Project #: 1003372 Application #: 12DRB-70173
Project Name: North Albuquerque Acres Tract A Unit B
Agent: RBA Architects L Phone #:

**CITY OF ALBUQUERQUE
PLANNING DEPARTMENT
July 25, 2012
DRB Comments**

**RE: Lot 30-A-3,, Block 11, Tract A Unit B, North
Albuquerque Acres**

12DRB-70173 MAJOR – SITE DEVELOPMENT PLAN FOR BUILDING PERMIT

SHEET NUMBER
A-10

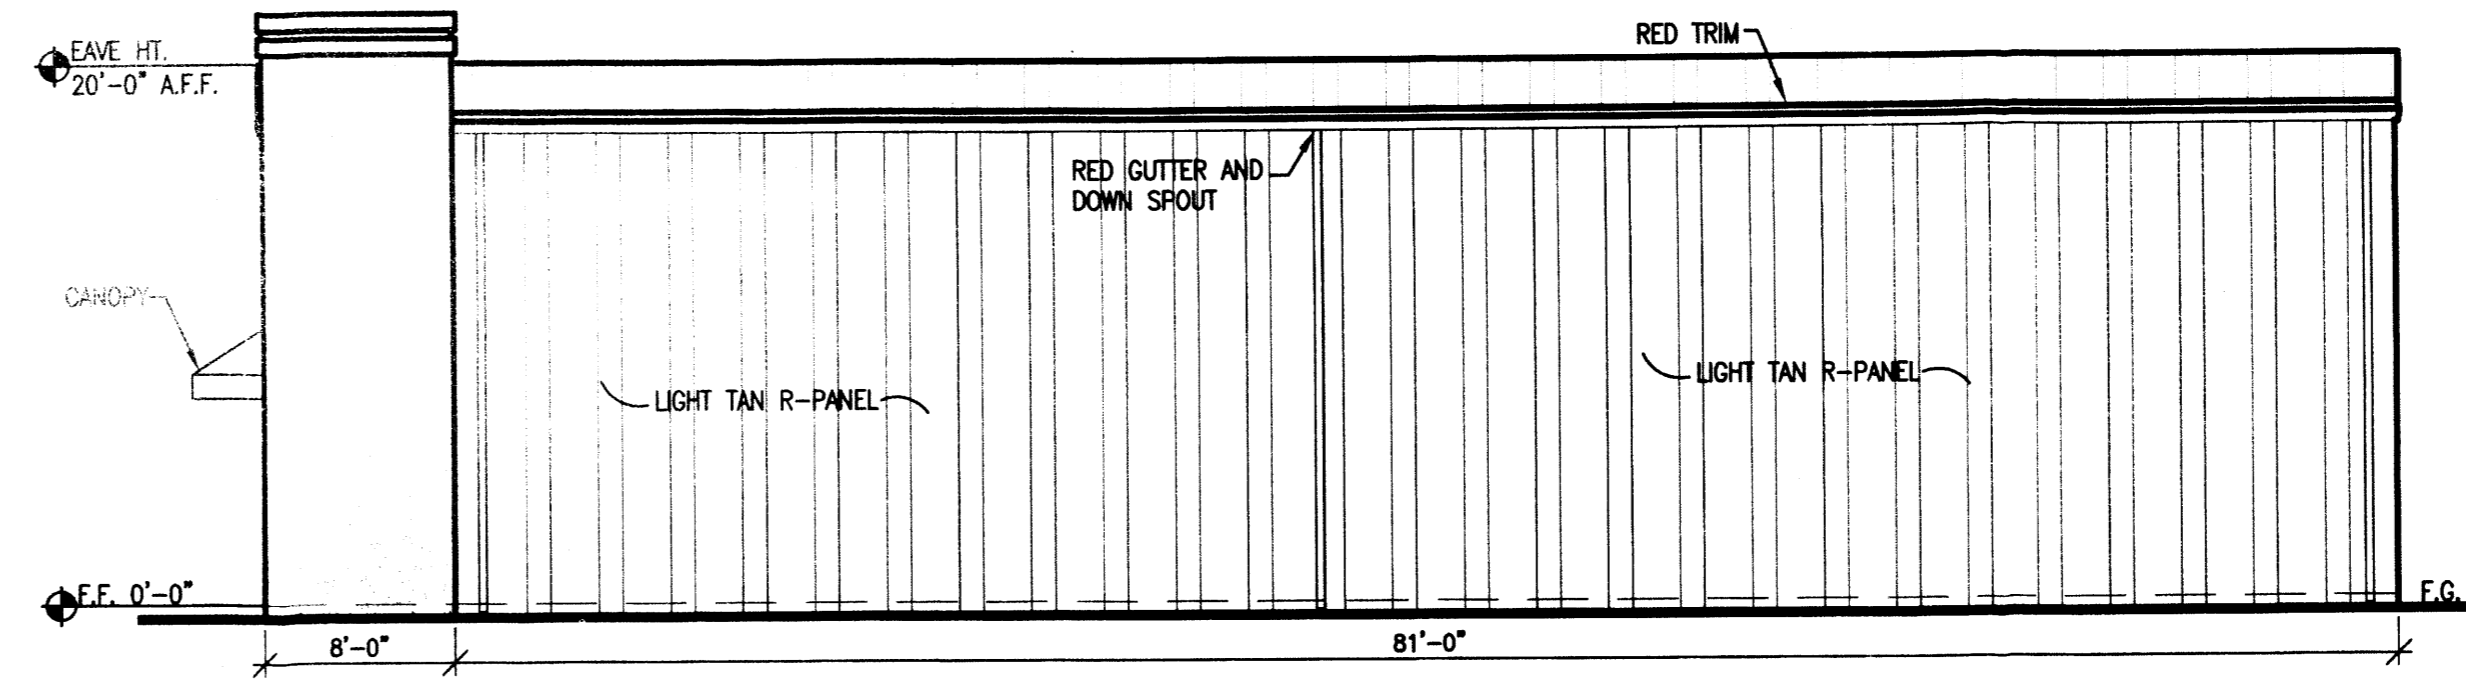
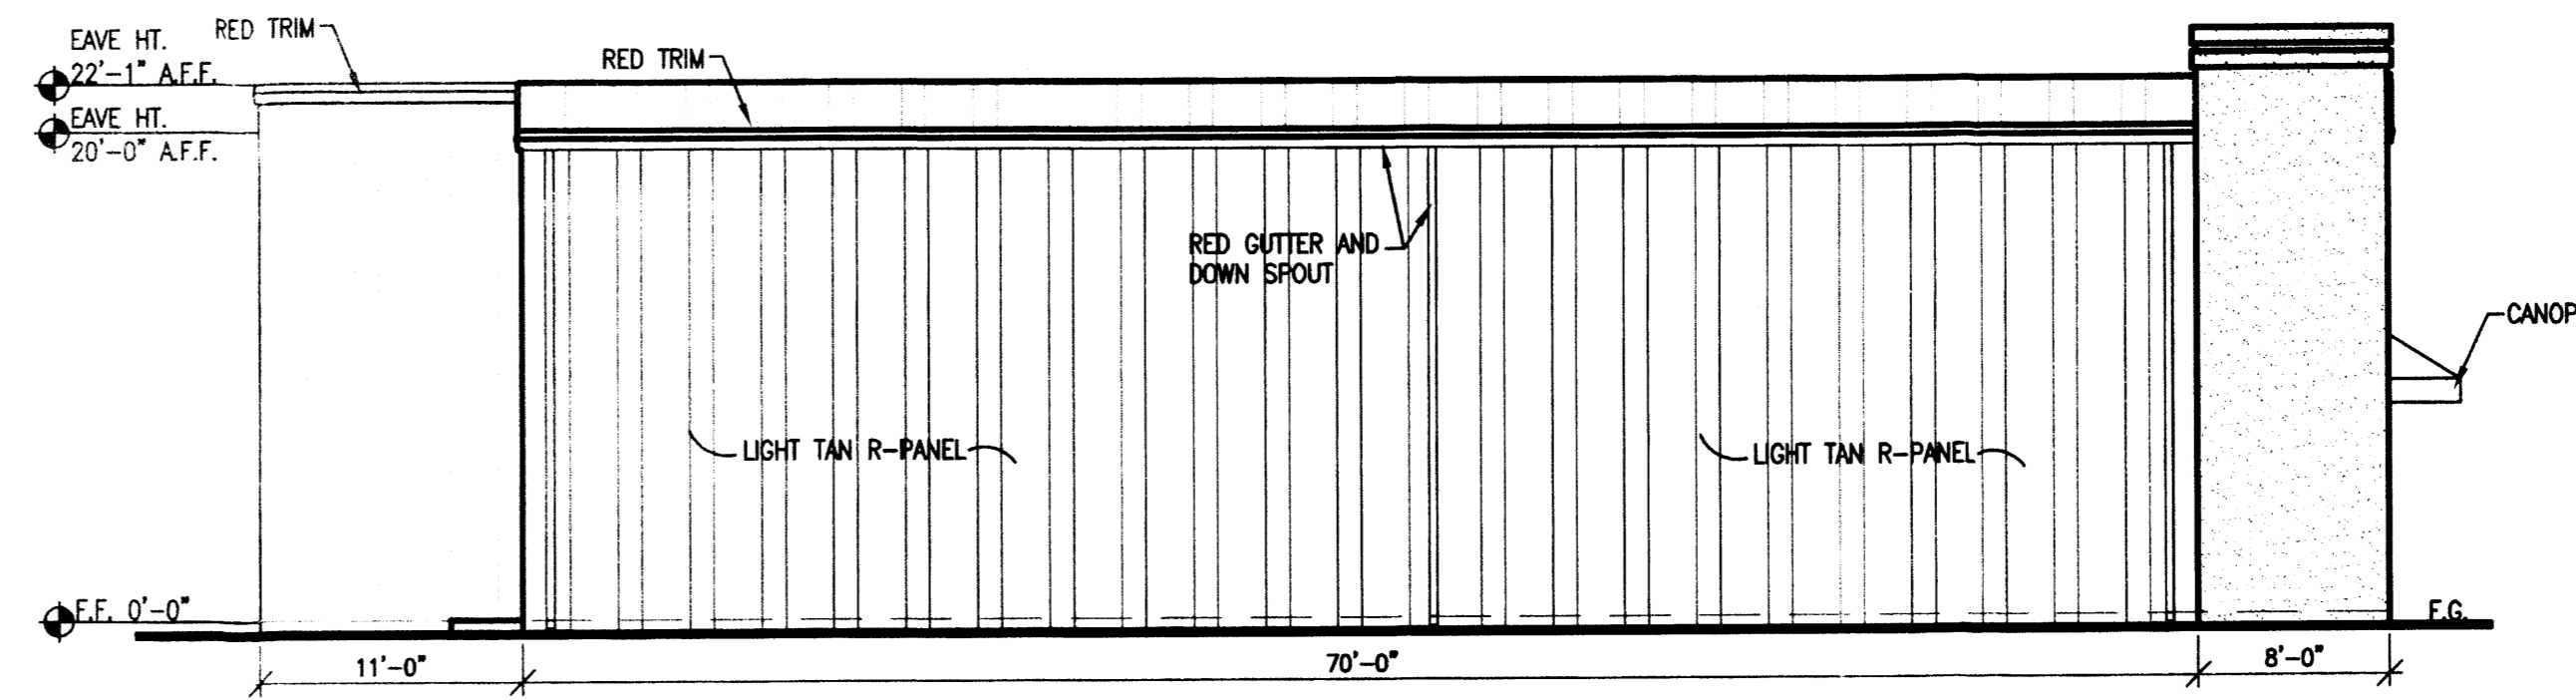
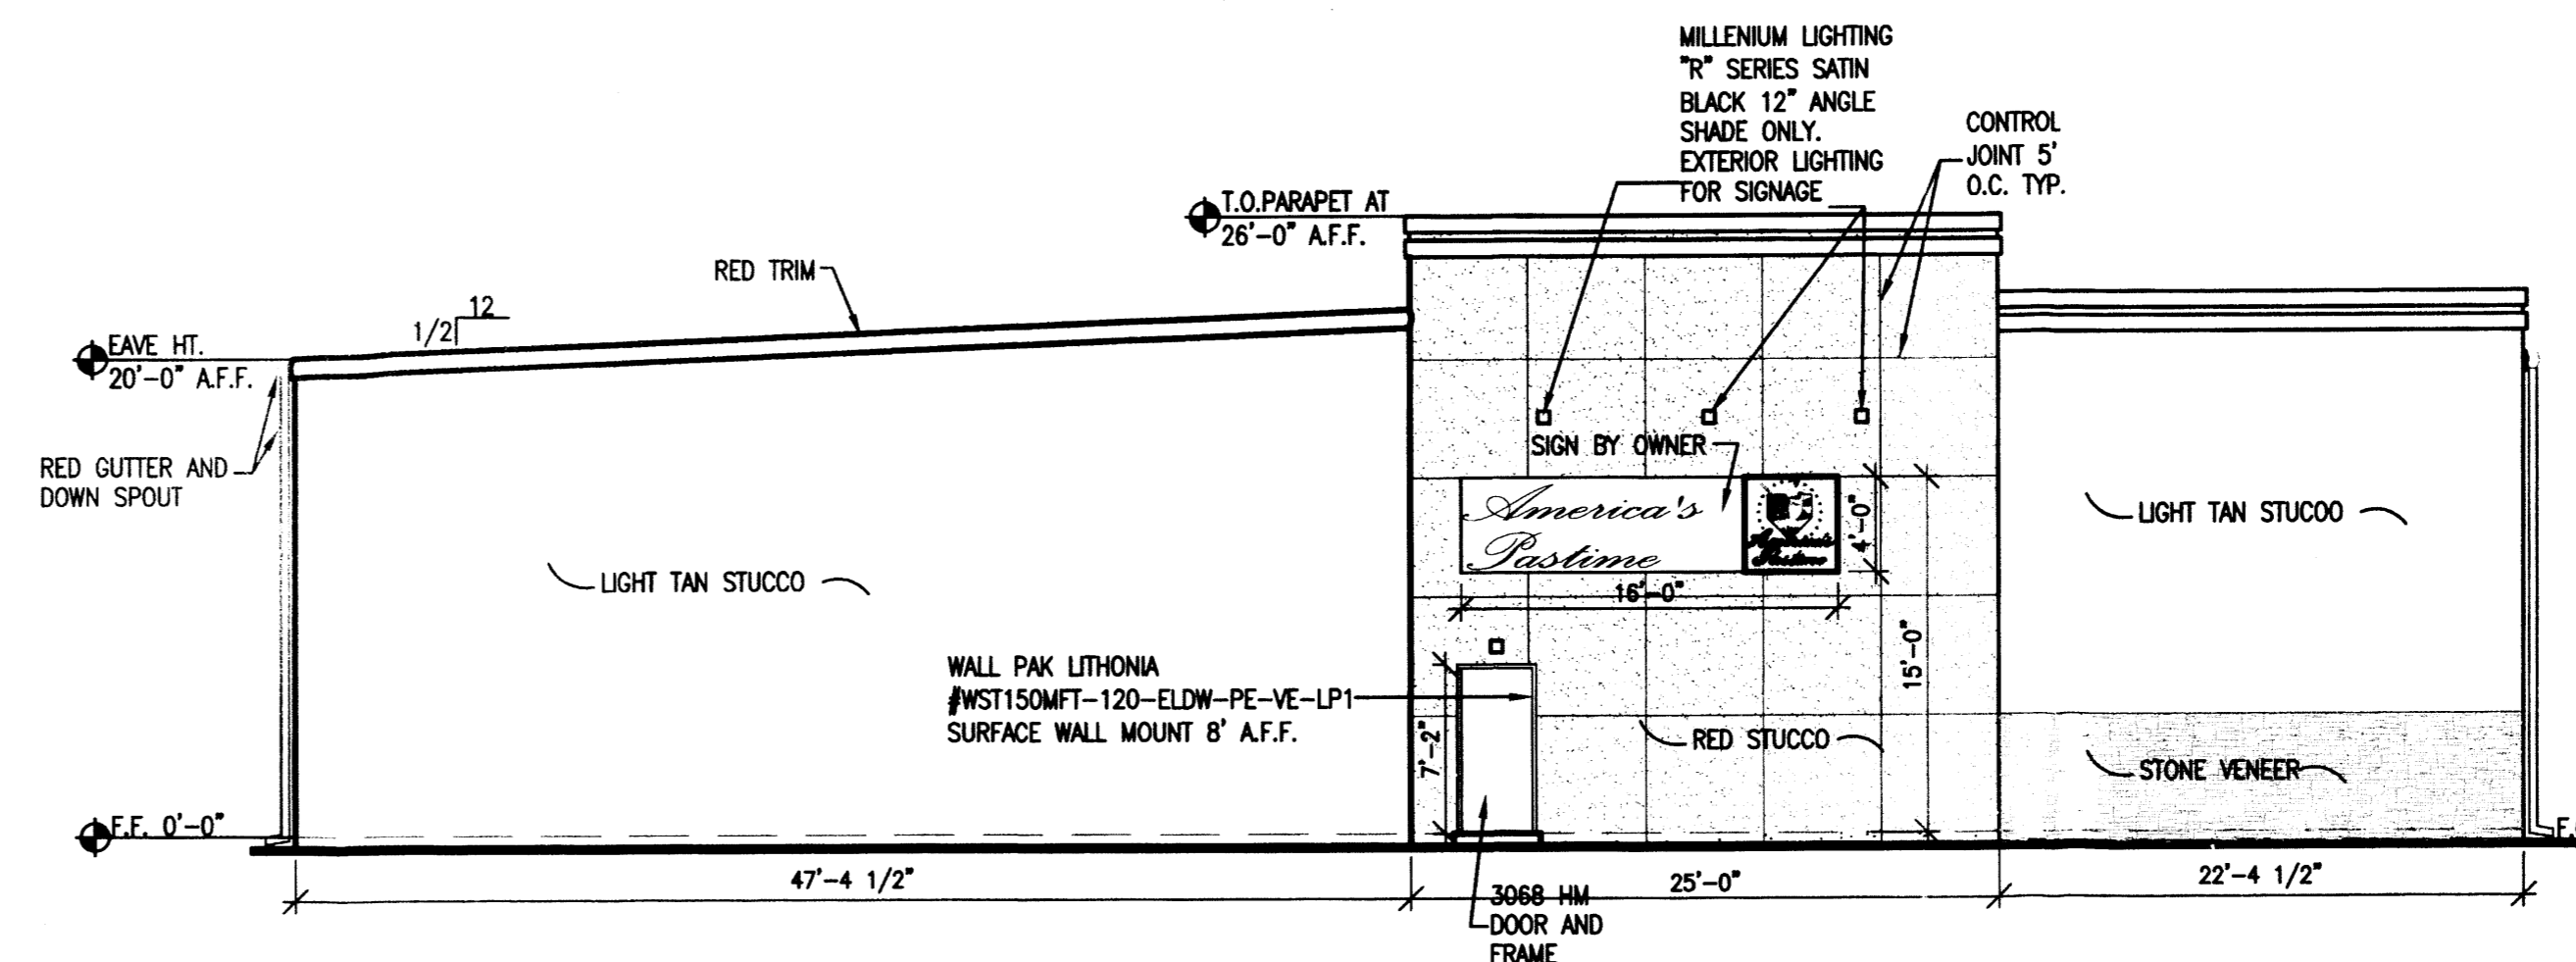
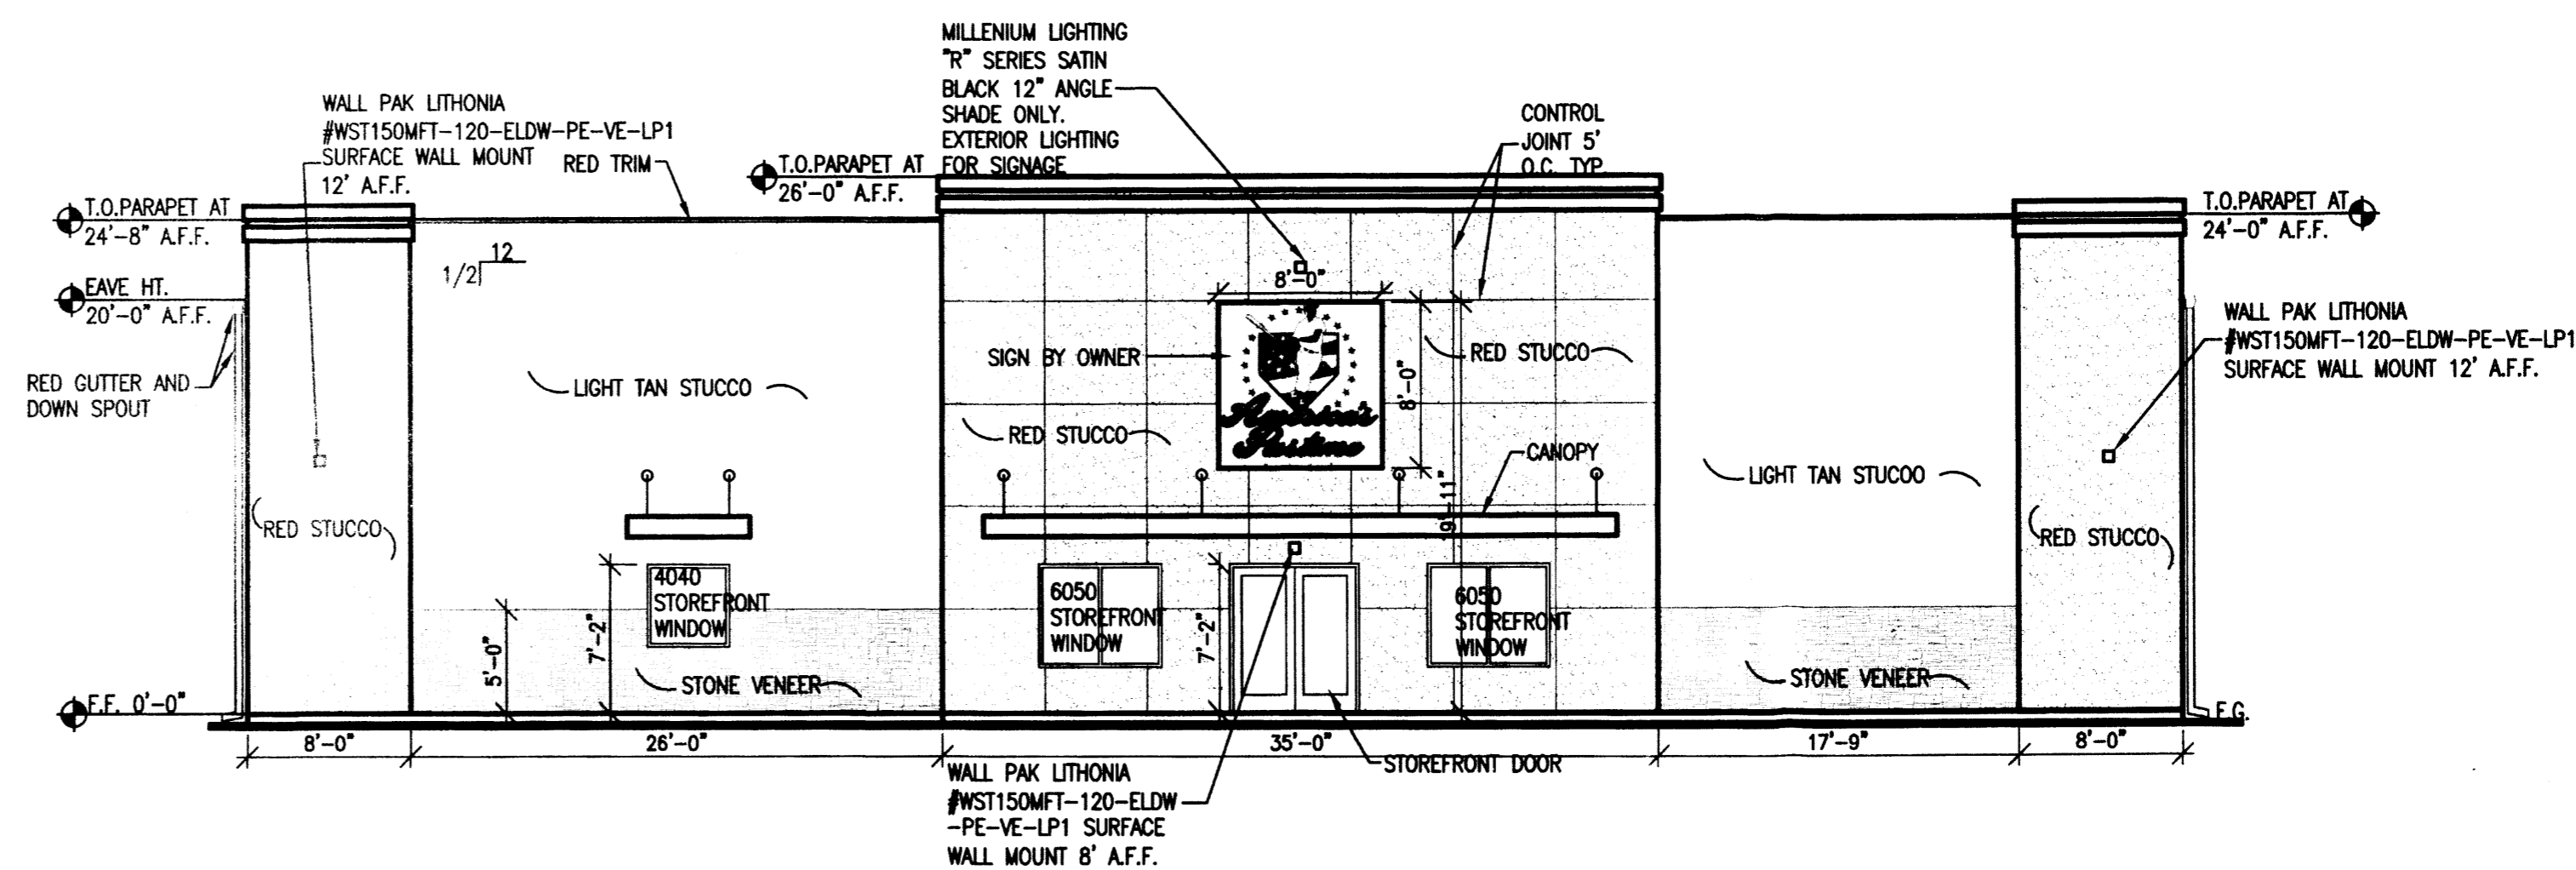
The proposed building does not comply with the Building Design Regulations of the North I-25 Sector Development Plan:

- b) 2. Street Façade must be articulated to provide a wrap around a distance of approximately 30 feet.
- b) 3. Additional articulation is needed to reduce the scale and composition of the large, flat building and to provide visual interest consistent with the Regional Commercial District (not Manufacturing).
- d) 2. Building Façade shall be quality material; predominant metal panels are not appropriate.
- d) 4. Metal panels do not convey a human scale and is inappropriate as primary building material.
- d) 5. Metal roof material does not reflect the design traditions of the Albuquerque region.
- e) 1. Screen wall must complement building material (stucco).
